Our Ref: EP/97/12/

26th October 2012

Side two storey extension, front dormer, front porch and new detached garage
2 Elm Avenue East Preston

SHEET: PROPOSED PLANS/ELEVS.

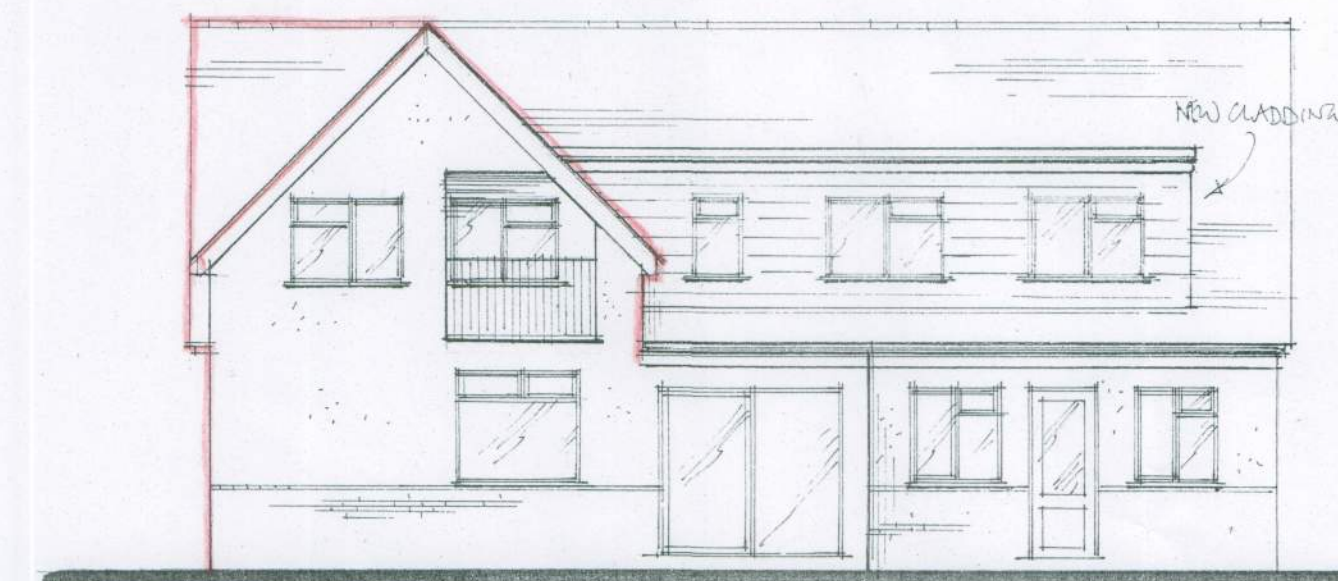
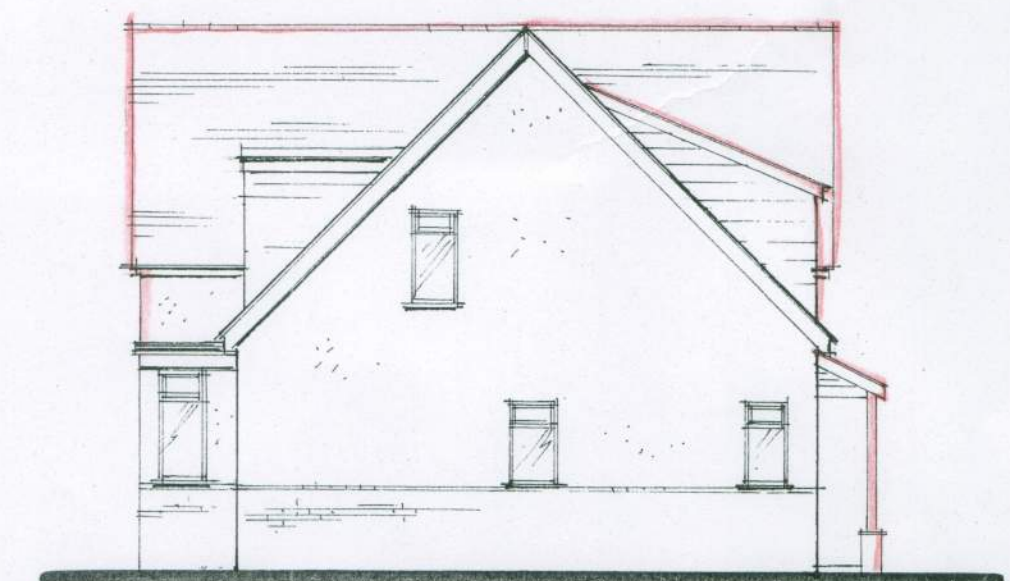
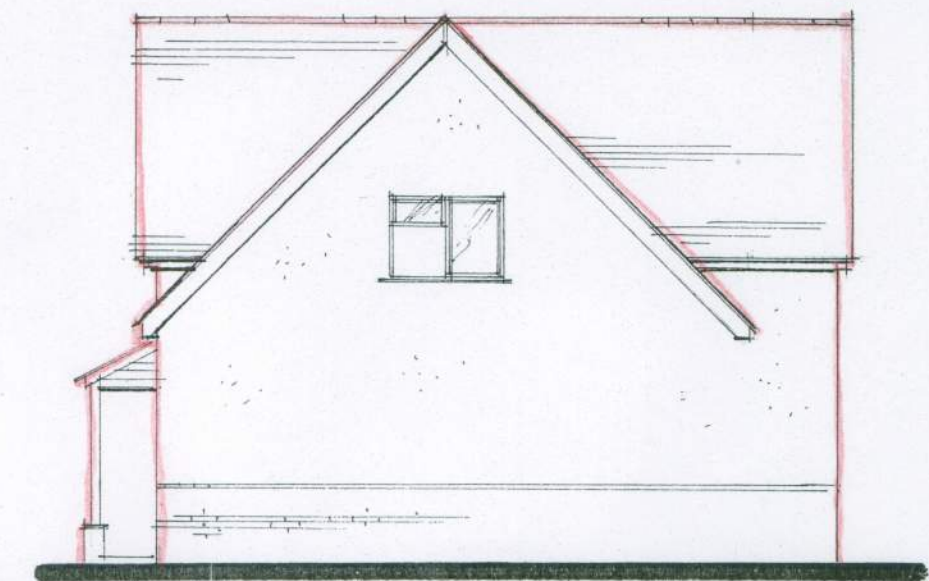
2. The use of shiplack cladding on the new garage and the facade of the house. This material is not used on any other building in the road, and its introduction would be contrary to policy DEV19, because the extension would not be visually integrated with the existing building in materials, while the use of this material on the extension and garage would compromise the pattern of the street; and the use of this material would also be contrary to the guidelines of the East Preston Village Design Statement, which emphasises that materials in new buildings should harmonise in both colour and texture with those in existing buildings in a road.

was omitted, and if the materials used on the house were brick and rendering to match the materials in adjoining houses.

PROPOSED NEW GARAGE
2 ELM AVENUE
EAST PRESTON

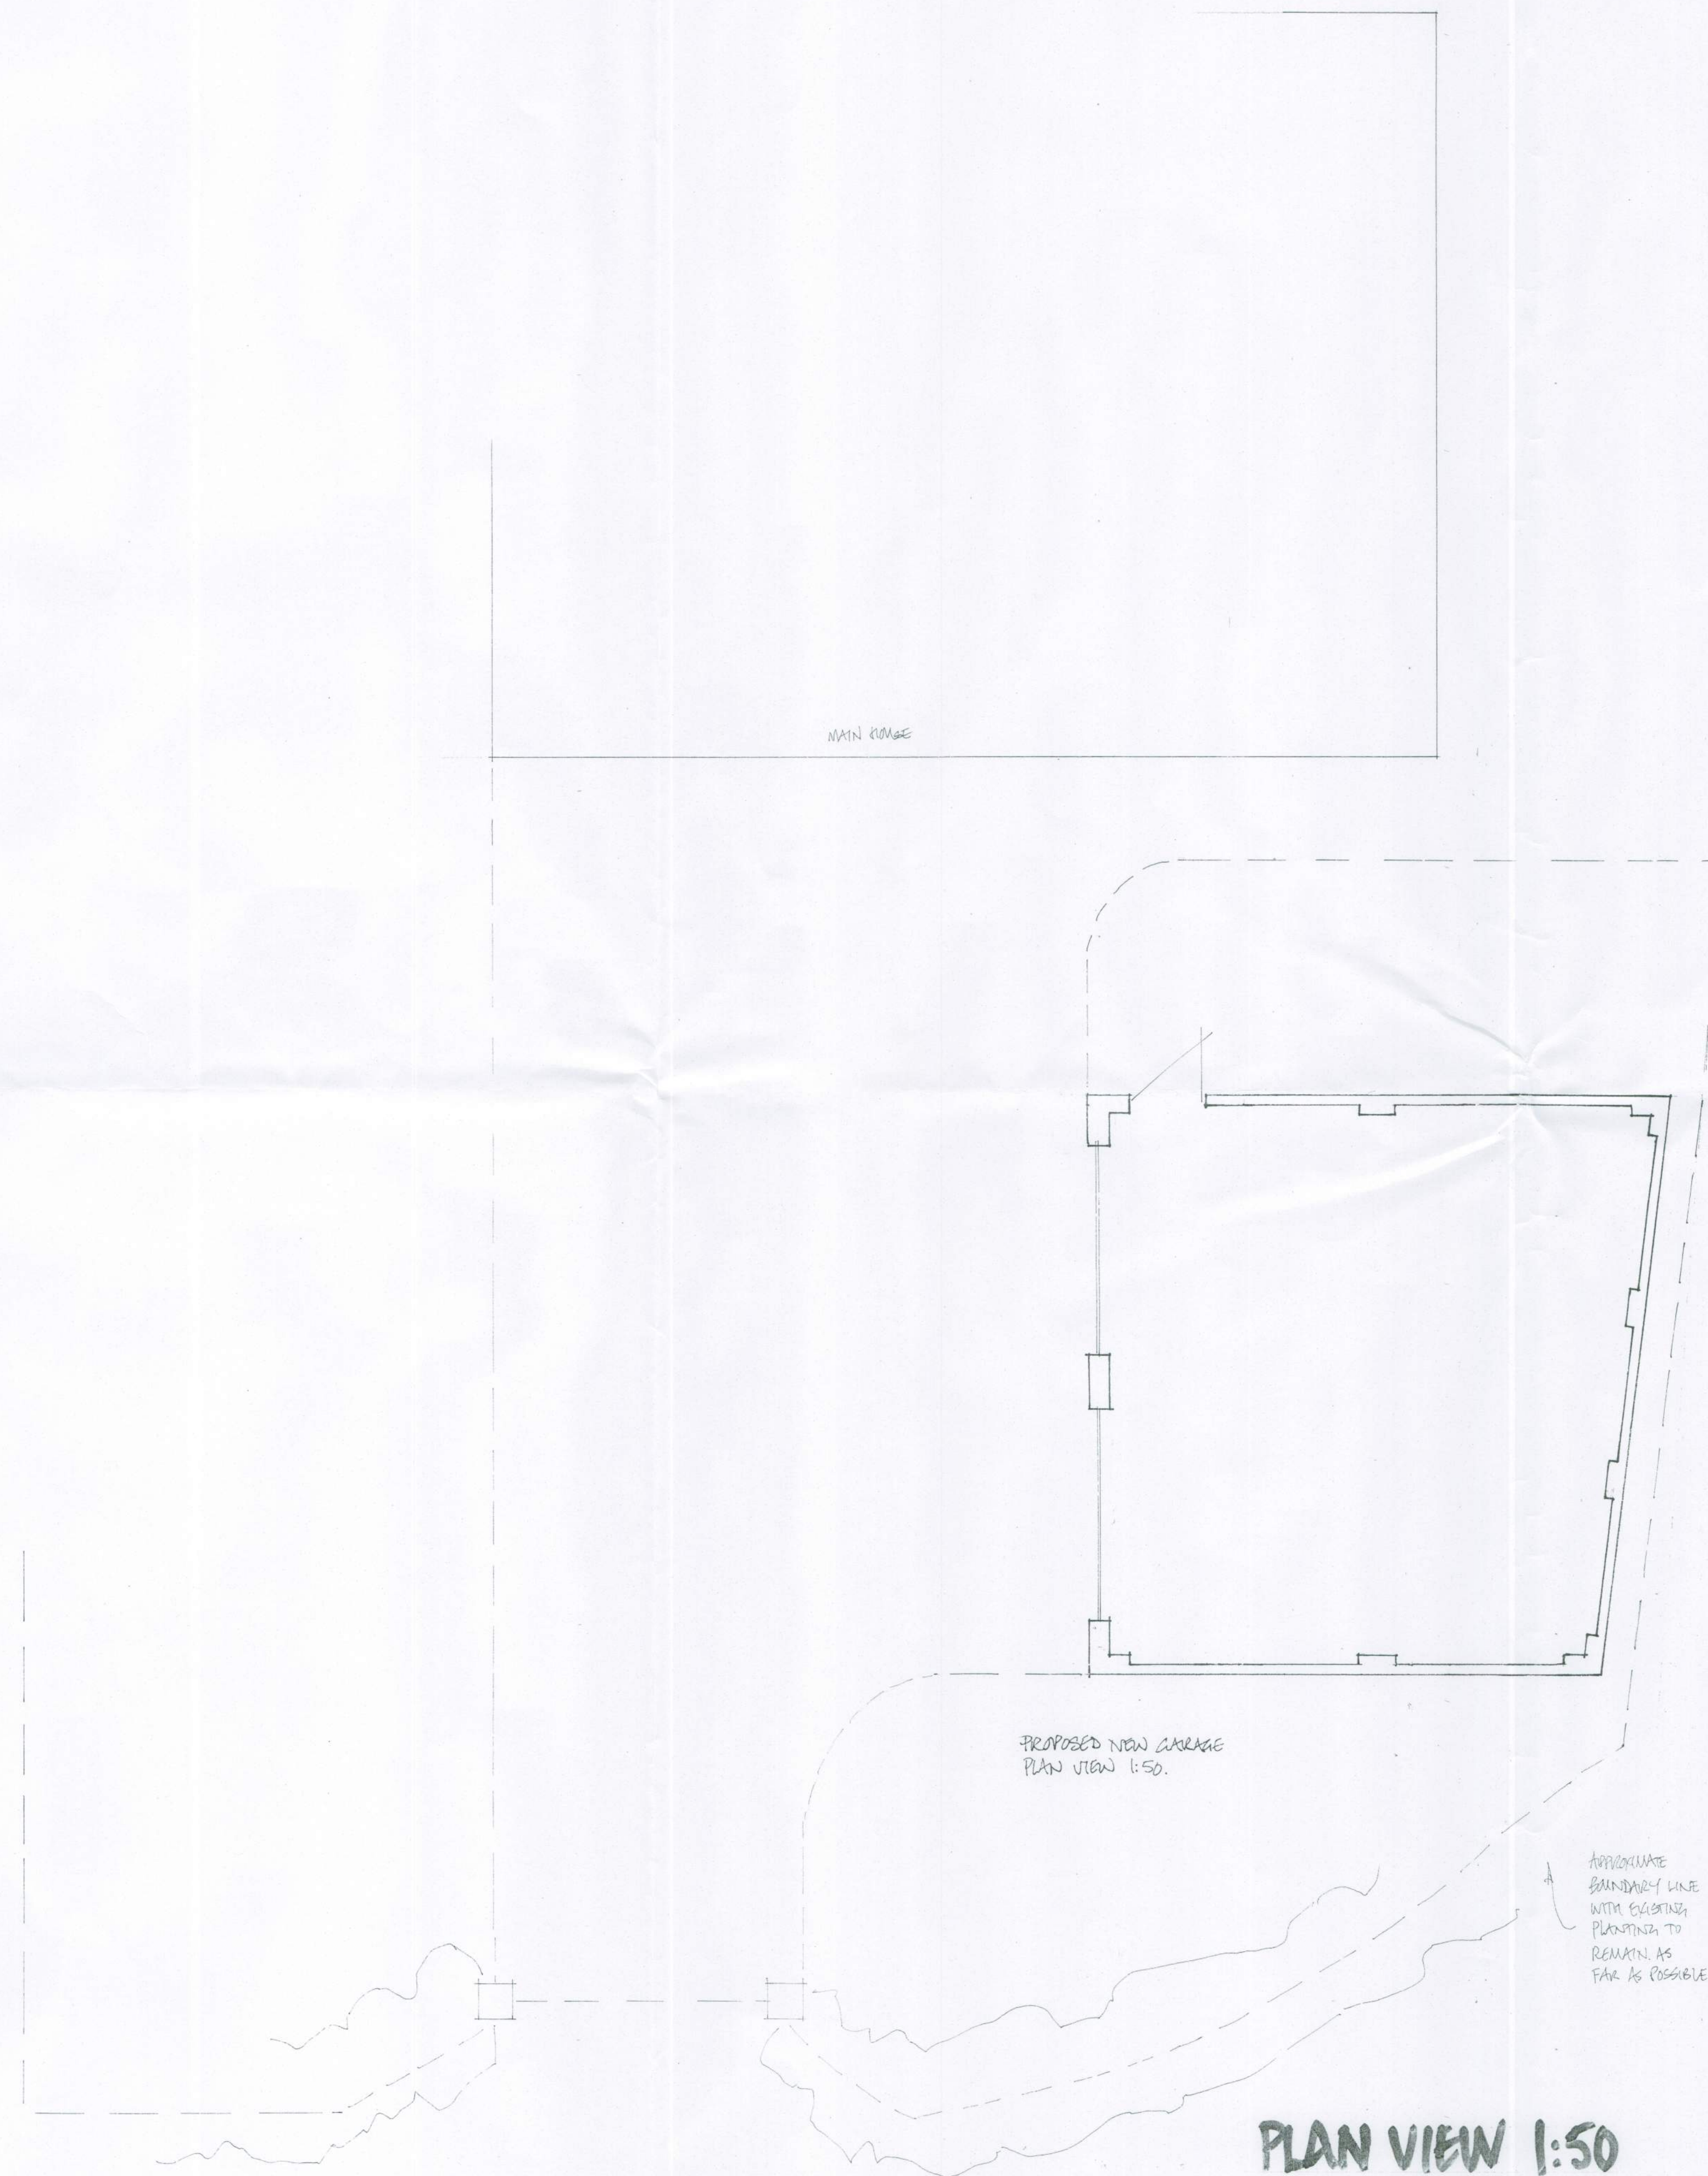
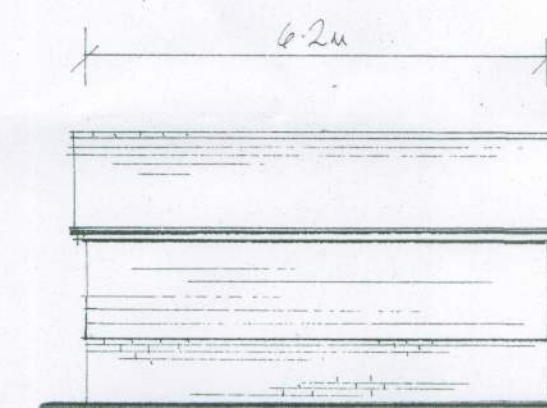
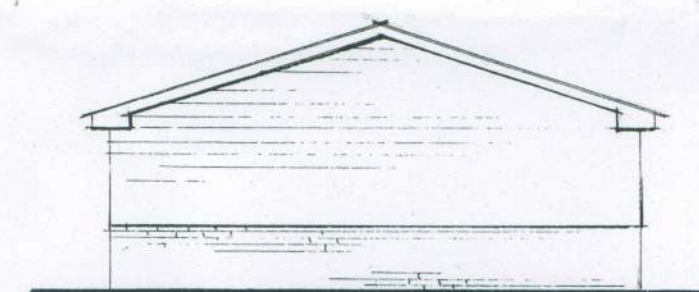
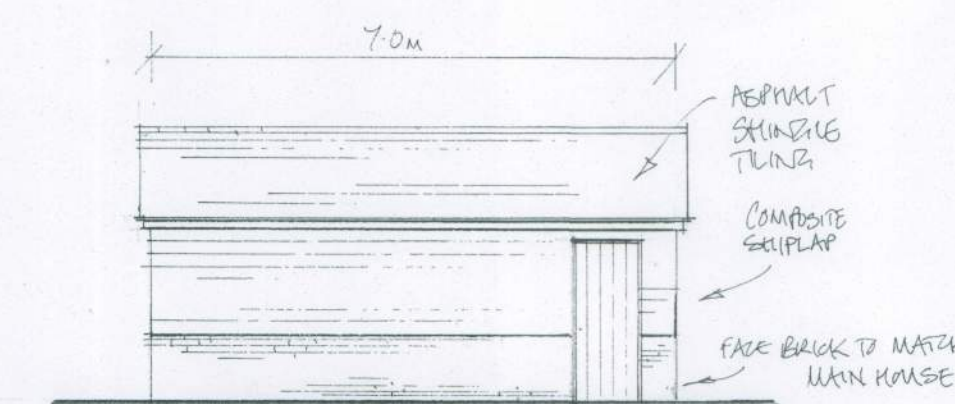
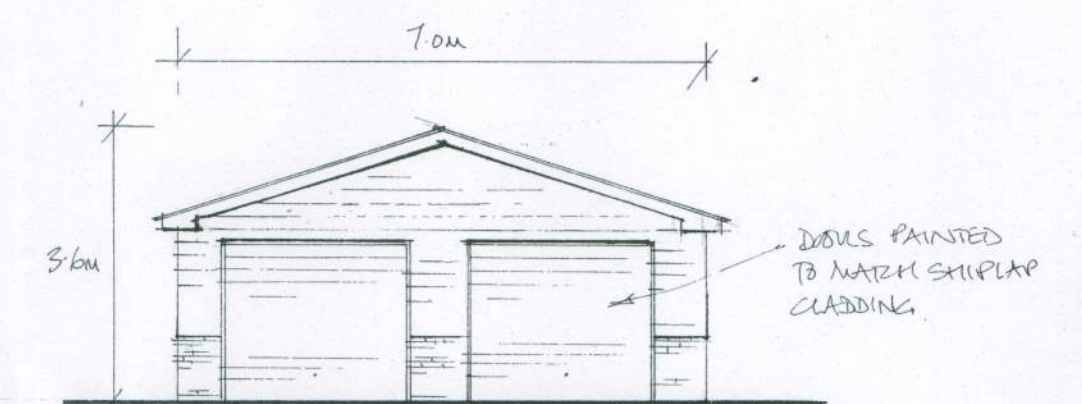
1. The position of the new garage, close to the road and ahead of any existing buildings in the road, would conflict with policy GEN7, because it does not respond positively to the characteristics of the site; with policy DEV19, because it affects the spatial character and pattern of the street; and with the guidance concerning the Elm Avenue Area of Special Character, which emphasises the importance of the regular building line in the area.

For these reasons, this application should be refused. It might be acceptable if the garage
